From: Downes, Scott G (DFW) <Scott.Downes@dfw.wa.gov>
Sent: Thursday, November 12, 2015 8:11 AM
To: Lindsey Ozbolt
Cc: Renfrow, Brent D (DFW); Harvester, Perry J (DFW)
Subject: RE: Big Creek Trails RZ-15-000001 Notice of Application
Attachments: WDFW comments on Big Creek Trails Proposed Development.pdf

RE: RZ-15-00001 Big Creek Trails

Thank you for the opportunity to comment on this proposal. The Washington Department of Fish and Wildlife (WDFW) has reviewed the SEPA checklist and supporting documents for the Big Creek Trails Rezone, Short Plat, and Shoreline Substantial Development Permit. We have some concerns over the proposed development and are submitting the following comments to be considered in review of the applicants permit evaluations.

RZ-15-00001

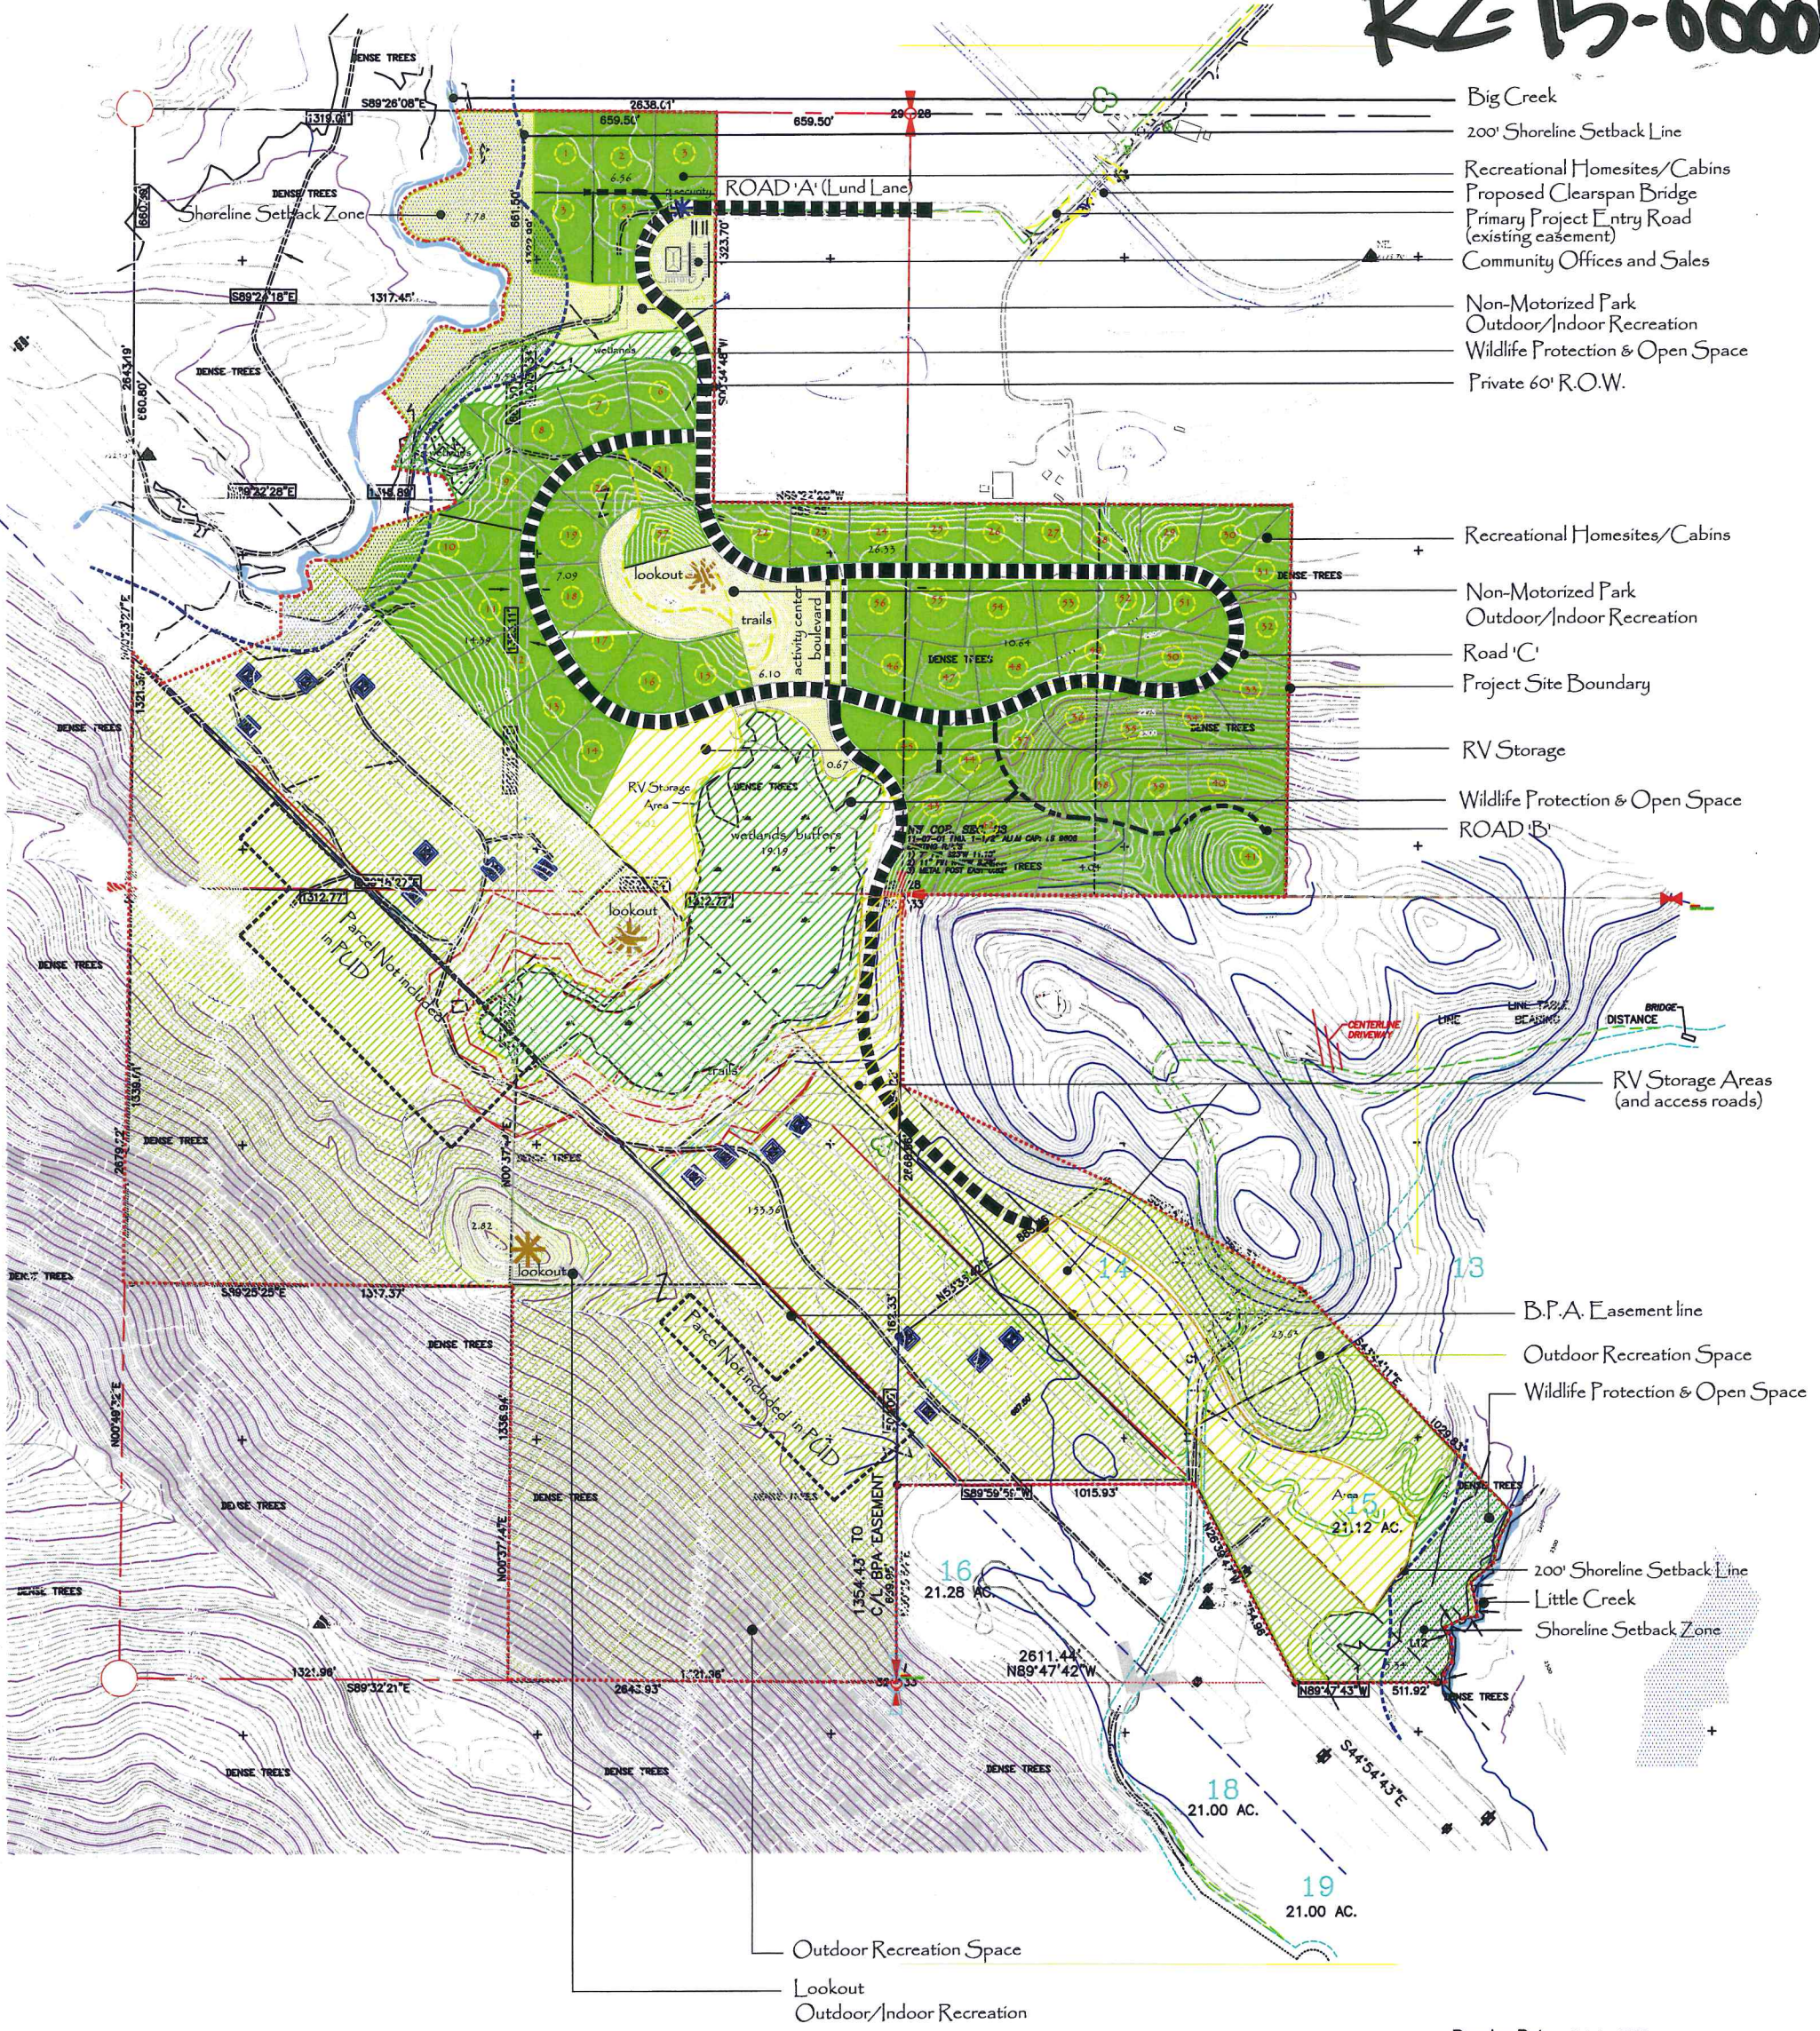
- The amended application states that no project construction within 200 feet of the OHWM of both Big and Little Creeks, including trails, picnic areas and parks. This will allow for the riparian areas of these two creeks that are important for fish habitat to remain relatively intact. WDFW would welcome the opportunity to work with you to develop the Shoreline Management Guidelines and other management plans/guidelines associated with the development. Stream associated wetlands are considered part of the shoreline areas and no project construction should occur in these areas, even if the wetland outer boundary is beyond 200 feet from the OHWM.

- WDFW appreciates that the applicant has grouped homesites to facilitate for the existence of open space and wildlife habitat. Perhaps the homesites could be further clustered. Currently shown on the site plans are two disjoint homesites from the other 56 homesites in the southeast corner of the property near Little Creek. These will be closer to National Forest lands, lead to further habitat fragmentation and development near forested lands which will influence future firefighting strategies and potentially lead to further displacement of wildlife movements. WDFW recommends that either these two homesites be eliminated from the site plan or that each parcel could be reduced and the 58 homesites could be fit into the footprint of the current 56 homesites.

- WDFW appreciates your efforts to maintain access for maintenance to the existing fish screen and irrigation delivery system. We would like to provide further review and comment on park facilities planned near the facility to ensure migrating fish are protected and not put at increased risk of harm by encouraging public viewing. Fish using fishways and near fish screens are already vulnerable and we do not want to exacerbate that risk.
